25-27 George Street, The Mercantile Hotel
SSDA Noise Assessment
Response to Submissions

SLR Consulting Australia Pty Ltd (SLR) provides the following responses to the comments/feedback received from the NSW Department of Planning and Environment (DPE) and the public relating to the noise assessment prepared by SLR (SLR ref: 610.17382-R02, dated 7 February 2018, "the SLR report").

Drawing Title
Proposed Roof Terrace Plan

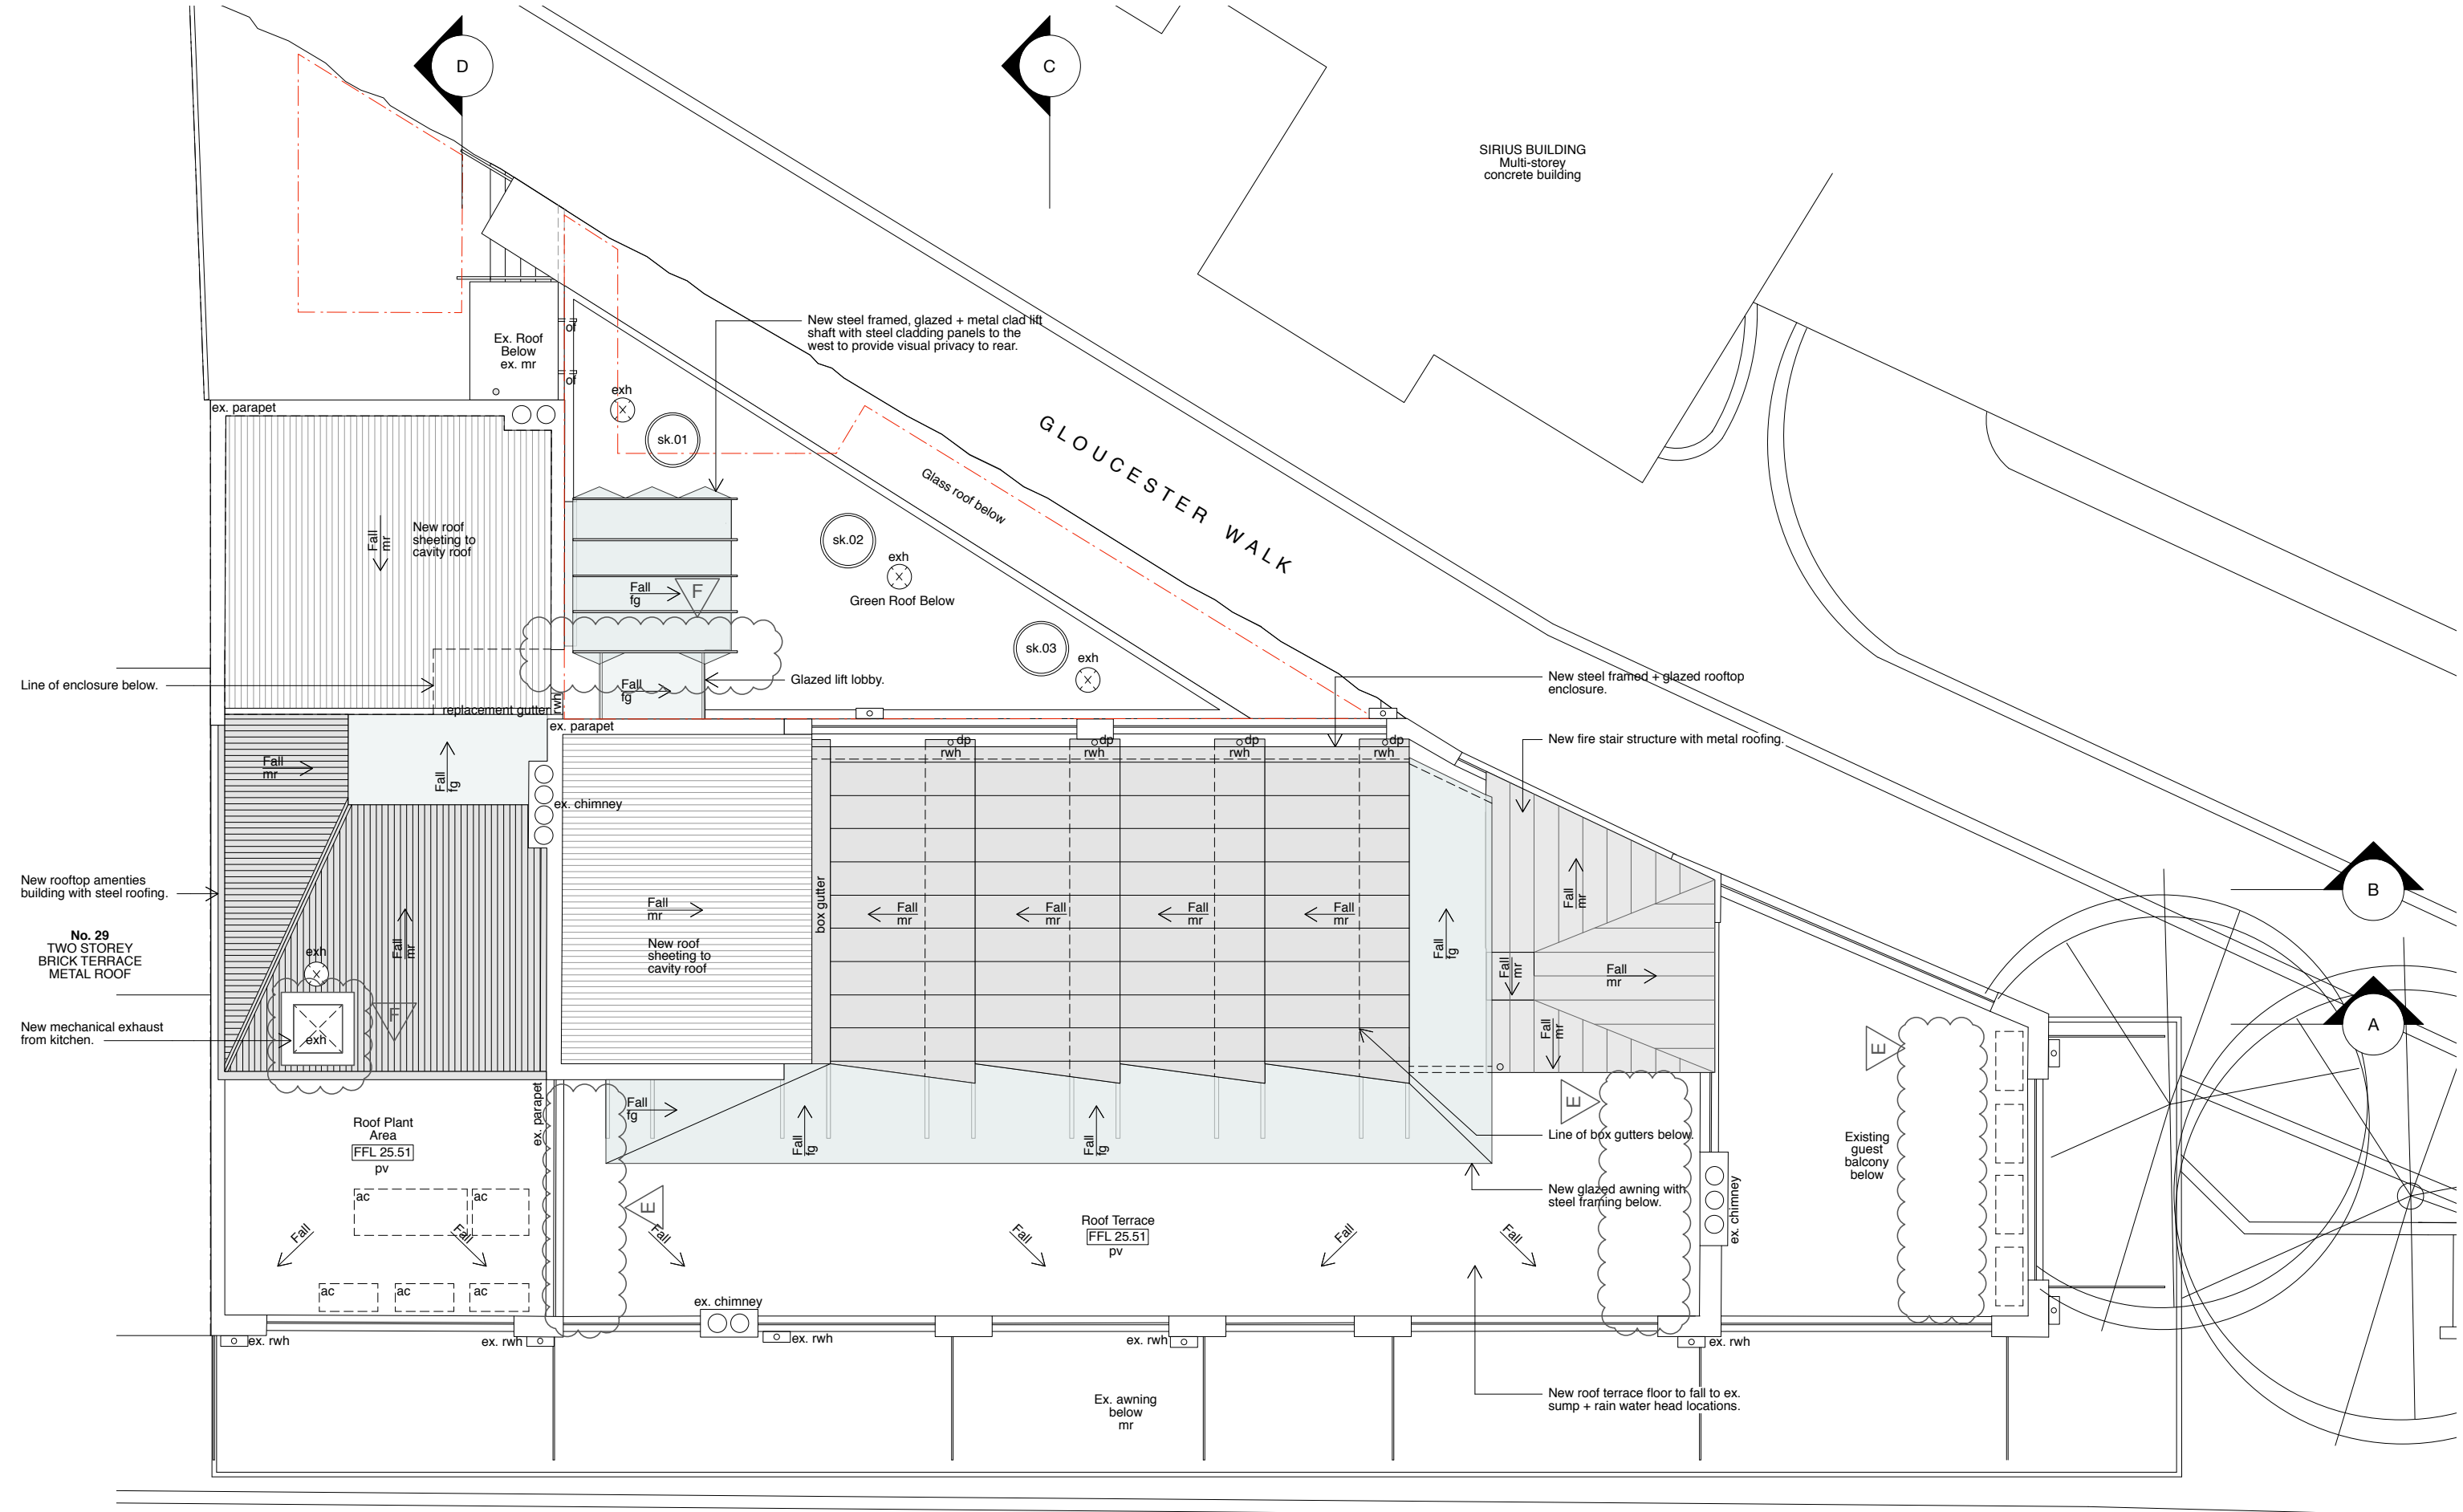
Give consideration to provision of screening at the northern end of the rooftop terrace (in addition to the proposed landscaping), in order to limit noise impacts.

When operated in accordance with the conditions listed in SLR report, impacts would not be expected. Screening in addition to that already proposed would therefore not be specifically required, but still may provide further acoustic benefit. Care would need to be taken if introducing screening to the north end of the rooftop as this may in fact result in reflected noise towards other receptors.
